Your Ref 20/02446/F

Thursday 29 October 2020

Proposal: Formation of inland waterways marina with ancillary facilities building, car parking, access and associated landscaping including the construction of a new lake - re-submission of 18/00904/F

Location: Glebe Farm, Boddington Road, Claydon, Banbury

Drawing Title PROPOSED SITE PLAN	Drawing Number A05/020	1
--	----------------------------------	---

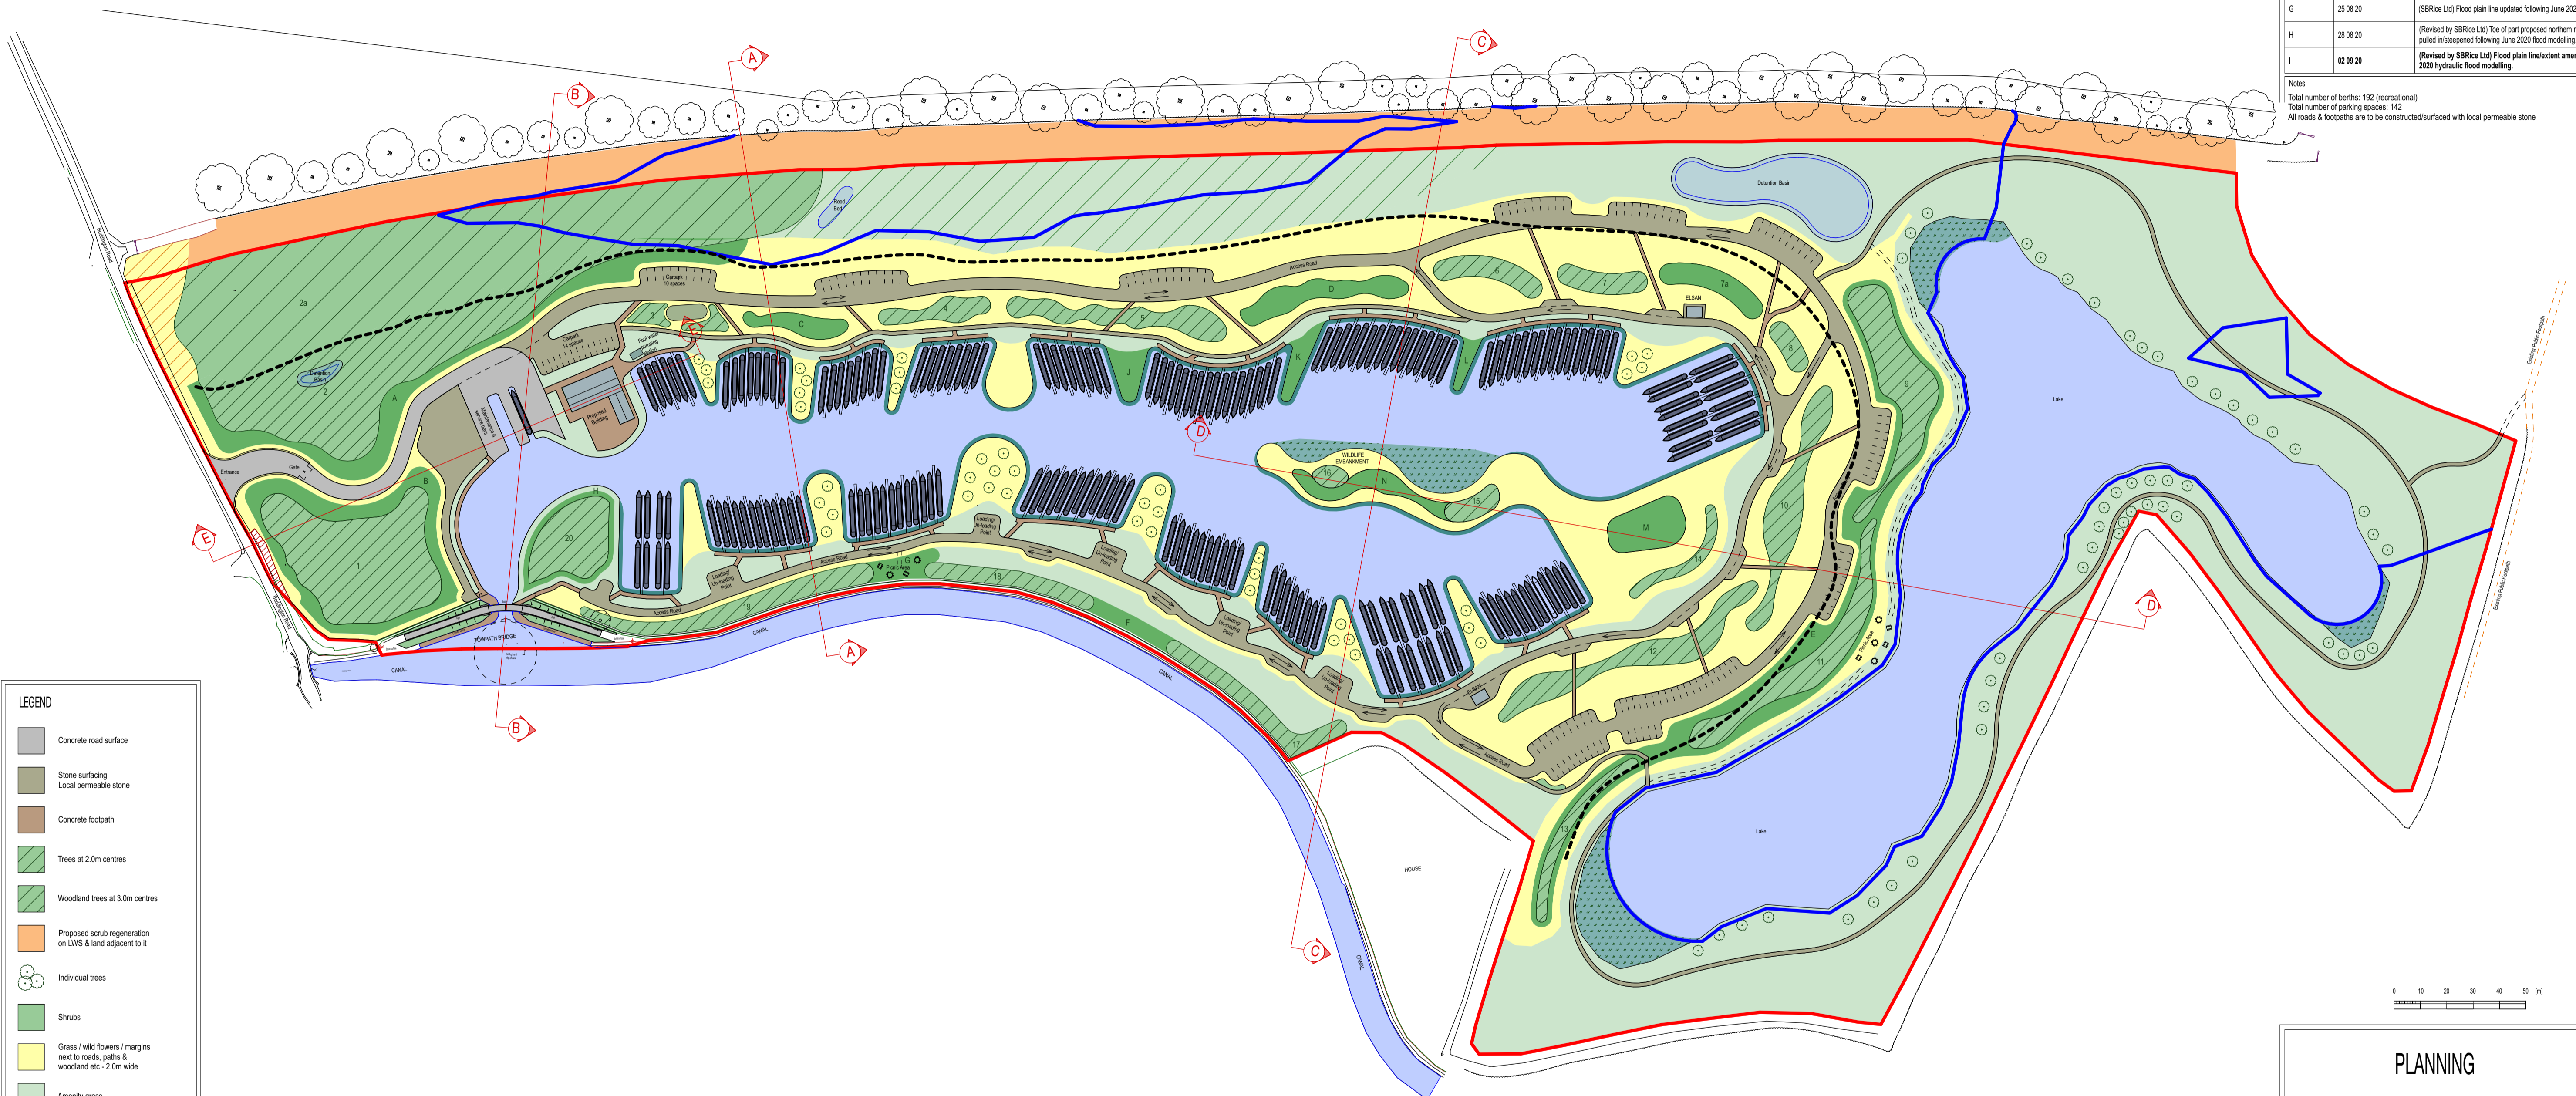
It is noted that an Elsan disposal point is provided within the facilities building, however, it is not clear from the submitted floor plans and site plan where general waste or recycling is to be stored. This should be clarified, and details provided as windblown waste and pollutants can not only have a detrimental impact on the visual amenity of the canal corridor but also be detrimental to wildlife.

The Trust have considered the impacts of the location of the marina entrance in relation to navigational safety and access along the towpath. No details have been provided on the dimensions of the entrance turning circle and bank protection will be required opposite the entrance and for 30m either side of the marina entrance central line to prevent erosion and scour caused by the turning movement of boats entering and exiting the marina.

- Surface finishes for the towpath bridge and approach ramps
- Brick finishes for the 'Geobag' retaining structure and details of the stop plank store door.
- Bank protection measures opposite the marina entrance and for 30m either side
- Maintenance and management regimes for the marina entrance and towpath bridge.

Drawing Title Drawing Number  
**TOW PATH  
 BRIDGE** **A05/601 B**

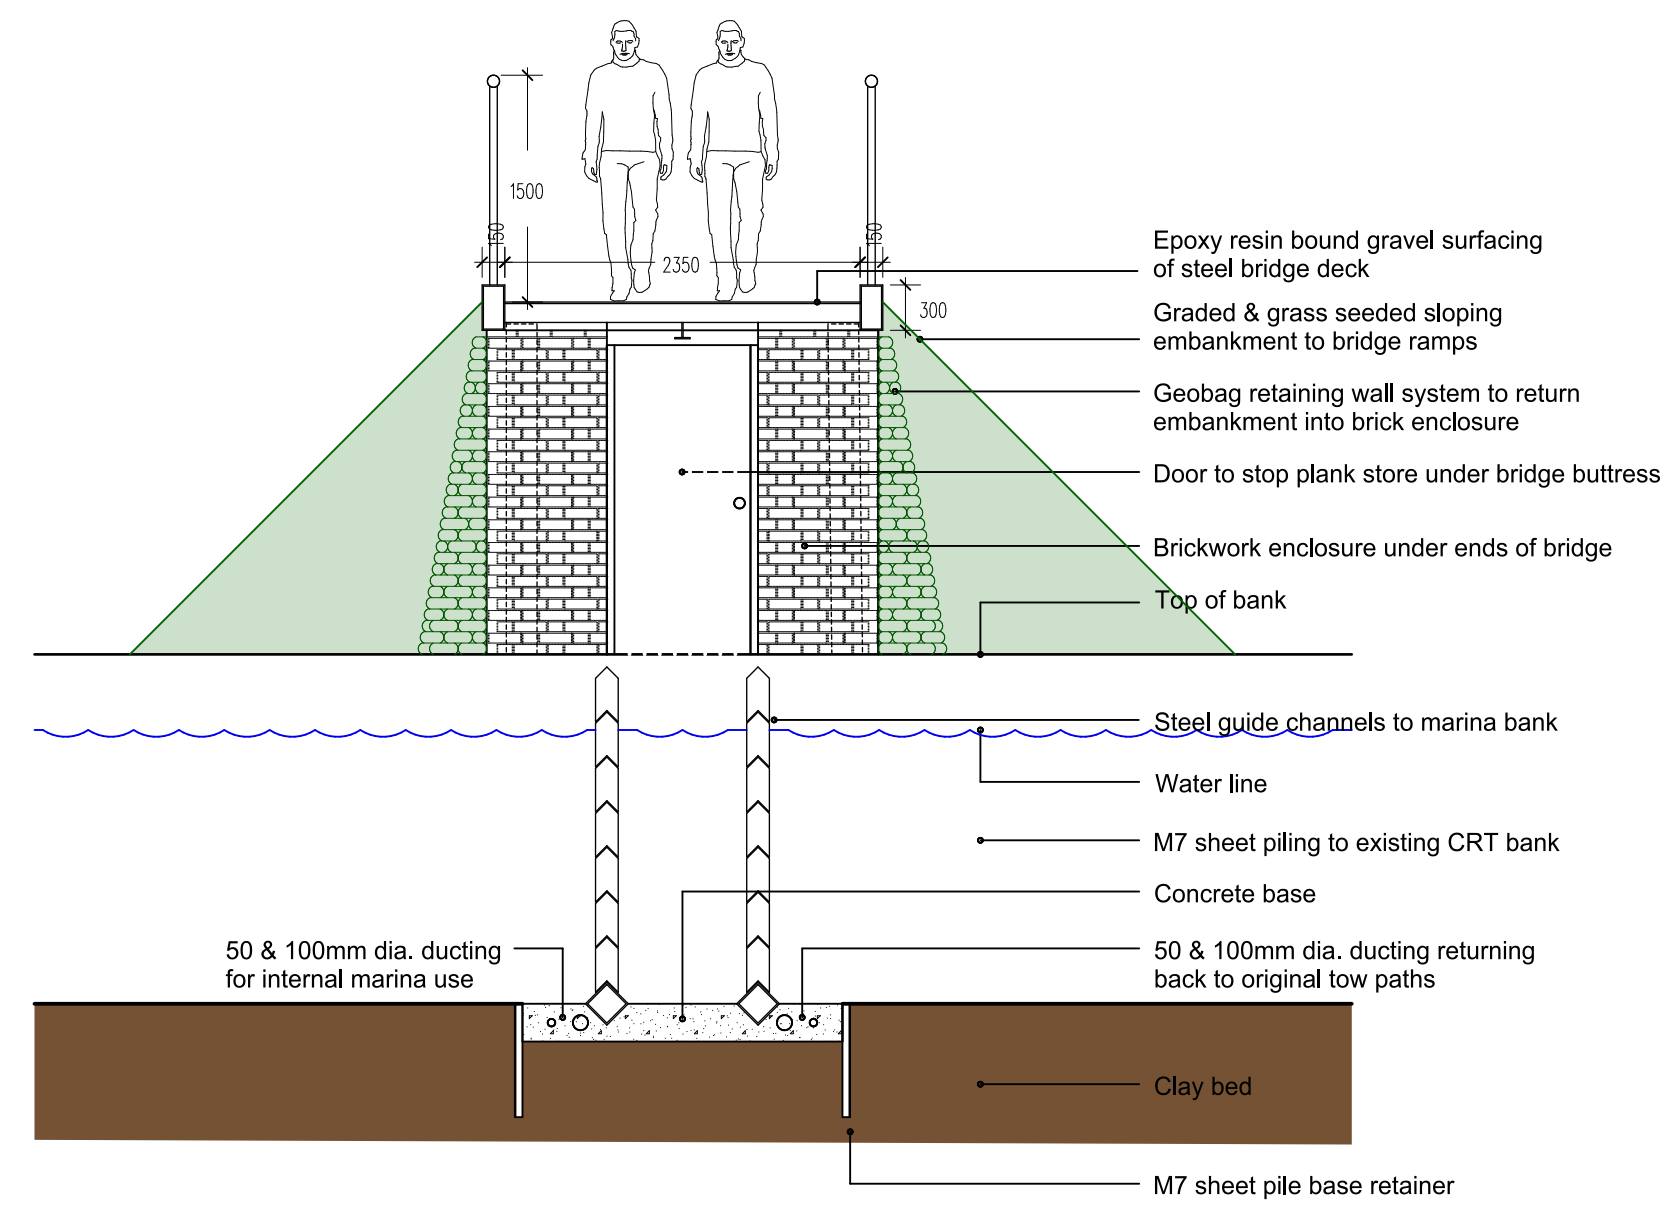
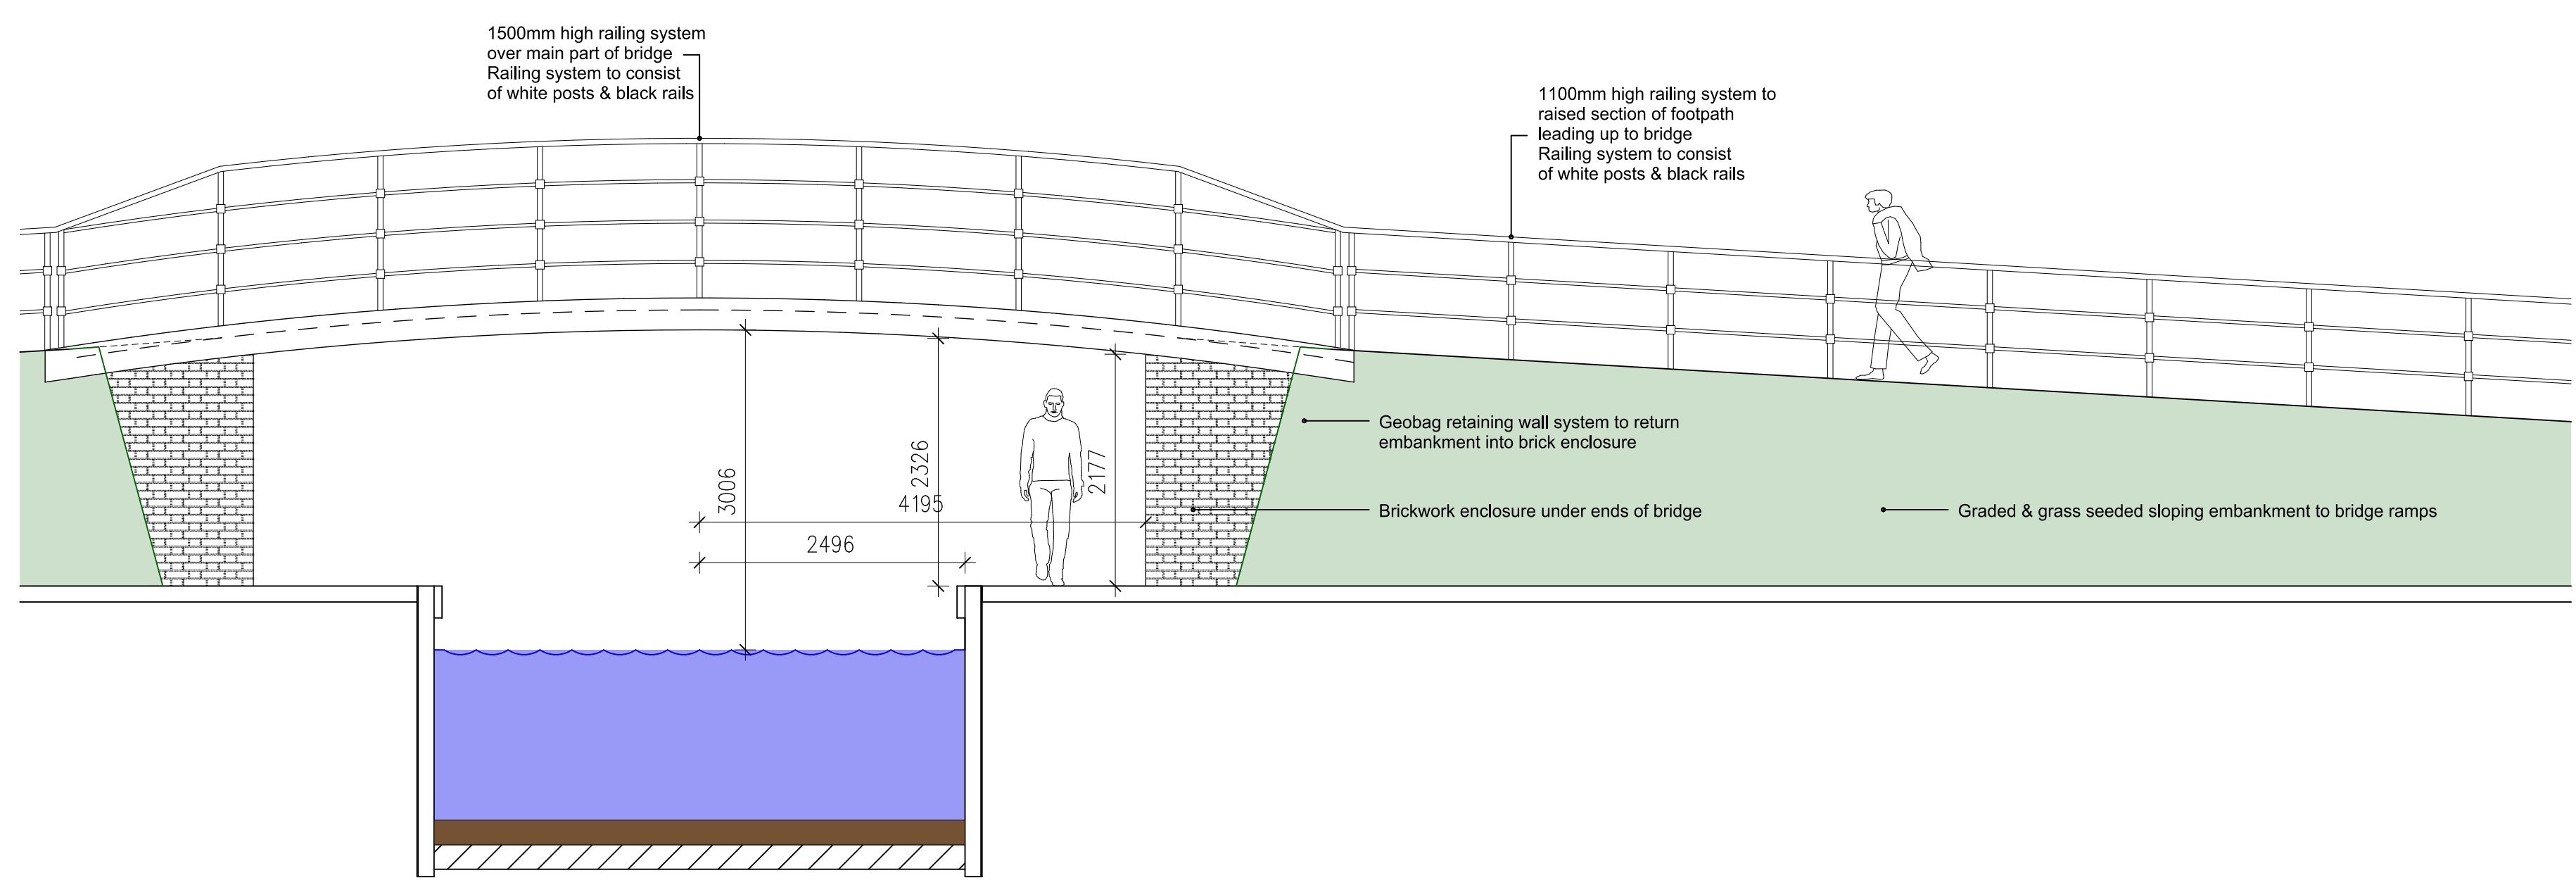
The overall approach to the new bridge design appears to be largely appropriate. The submission indicates a store will be included beneath the approach ramp for the storage of stop planks, and the doors to these should be designed to complement the bridge materials and colours. The bridge drawings indicate an epoxy resin bound finish on the metal bridge deck, and it needs to be demonstrated that this is slip proof and durable enough not to become delaminated over time. The ramp to the bridge should also be finished in the same material as the deck, to provide a seamless, high-quality finish.

The submission indicates that the 'Geobag' retaining structure to the bridge will be covered by a mixture of grass embankment and brickwork. It is important to ensure that the retaining structure is not to be visible at all and we wish to see further details of the proposed brickwork. Further clarification of the bridge attributes will be required by the Trust through our Marina process however it should be noted that the bridge currently shows a clear span width of 2350mm however the Trust will require a minimum clear width of 2.5m.

Therefore, whilst the general design of the bridge is considered acceptable the final detailed design, including details on maintenance/management, should be required by condition. The Trust wish to be consulted on these details when they are available.
